**KITTITAS COUNTY**  
**DEPARTMENT OF PUBLIC WORKS**

**MEMORANDUM**

TO: Scott Turnbull, Community Development Services  
FROM: Christina Wollman, Planner II *cw*  
DATE: March 17, 2008  
SUBJECT: Plat of Ponderosa Pines P-07-42

Our department has reviewed the plat application and has the following comments:

DRAWN BY: KH	DATE: JUNE 26, 2007	JOB # 07-278 PLAT.dwg COMP 01-504-5.crd KB
CHECKED BY: J. BENTLEY	SCALE: 1" = 200'	SHEET 1 OF 2

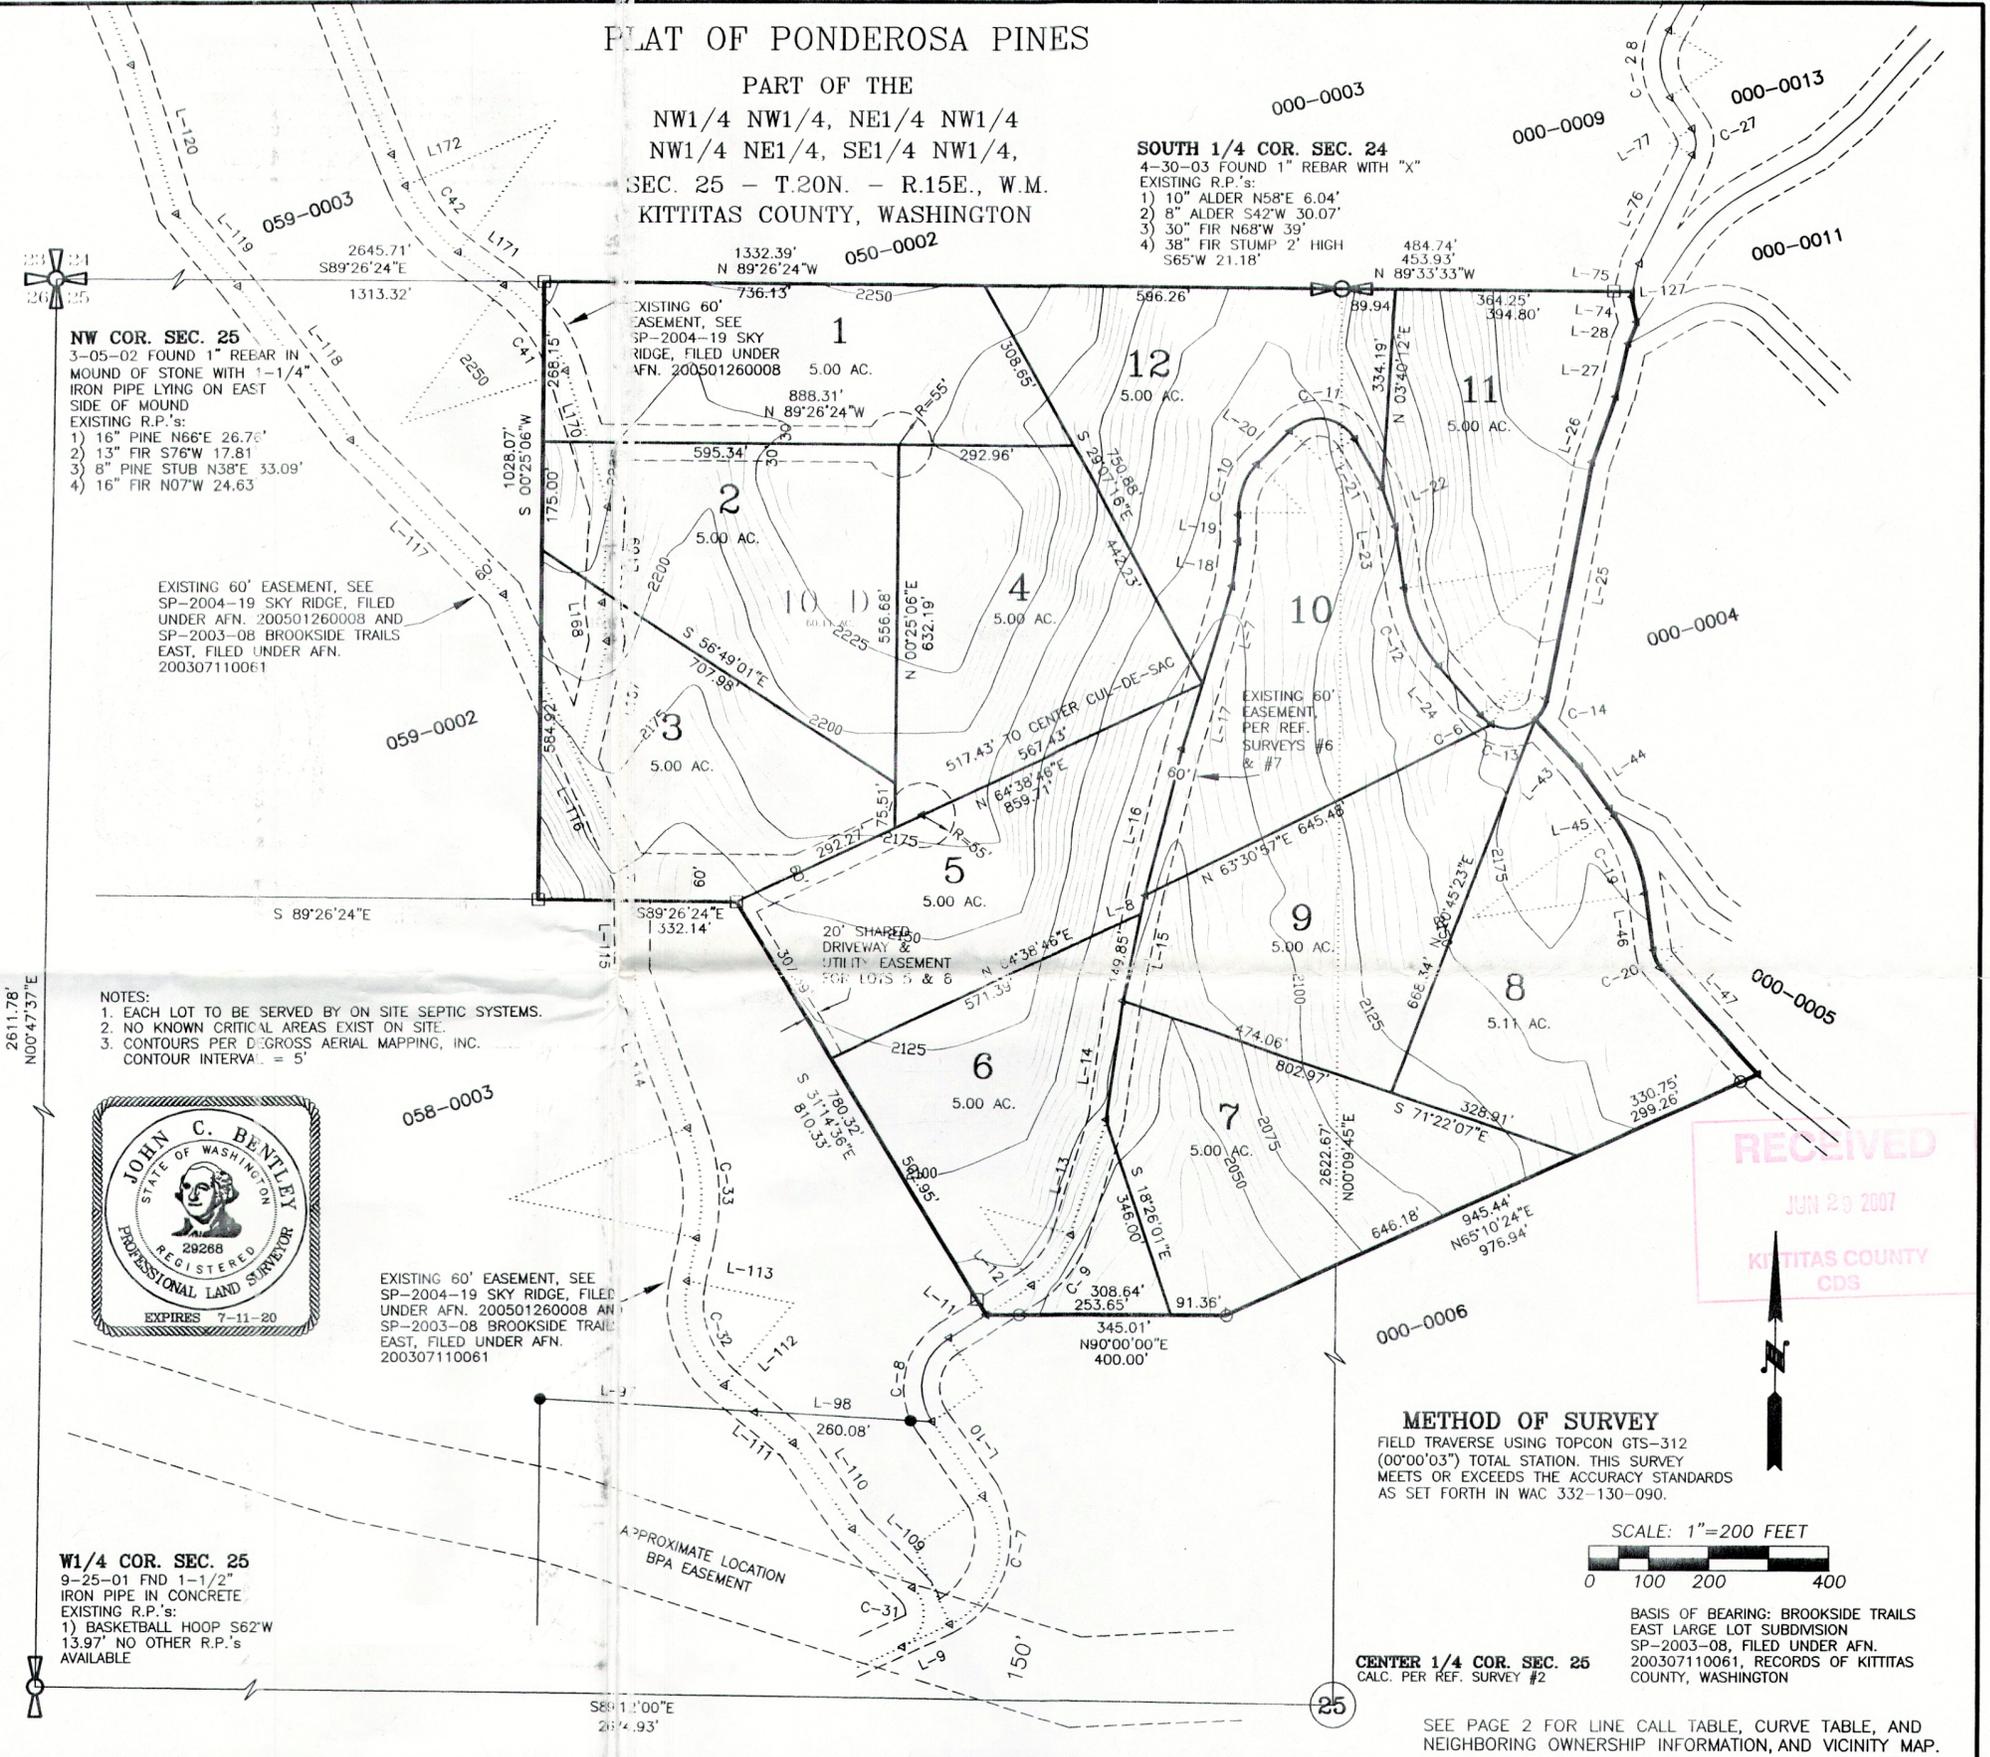
3. Private Road Improvements: Access from Columbia Avenue to the final access points on Jack Pine Drive, Creekside Road, and Owl Ridge Drive, and the second access from Jack Pine Drive to Montgomery Avenue shall be constructed to meet or exceed the conditions of a Low-Density Private Road. See Kittitas County Road Standards, 9/6/05 edition.

- a. Access easements shall be a minimum of 60' wide. The roadway shall have a minimum width of 20', with 1' shoulders, for a total width of 22'.
  - b. Minimum centerline radius will be 60'.

4. Cul-de-Sac: A turnaround is required on Creekside Road. The applicant has the option to either build a turnaround near the intersection of Creekside and Owl Ridge Roads, or to certify Creekside Road from Columbia Avenue to an existing offsite cul-de-sac. If the second option is chosen, the easement up to the cul-de-sac must be shown on the face of the plat.
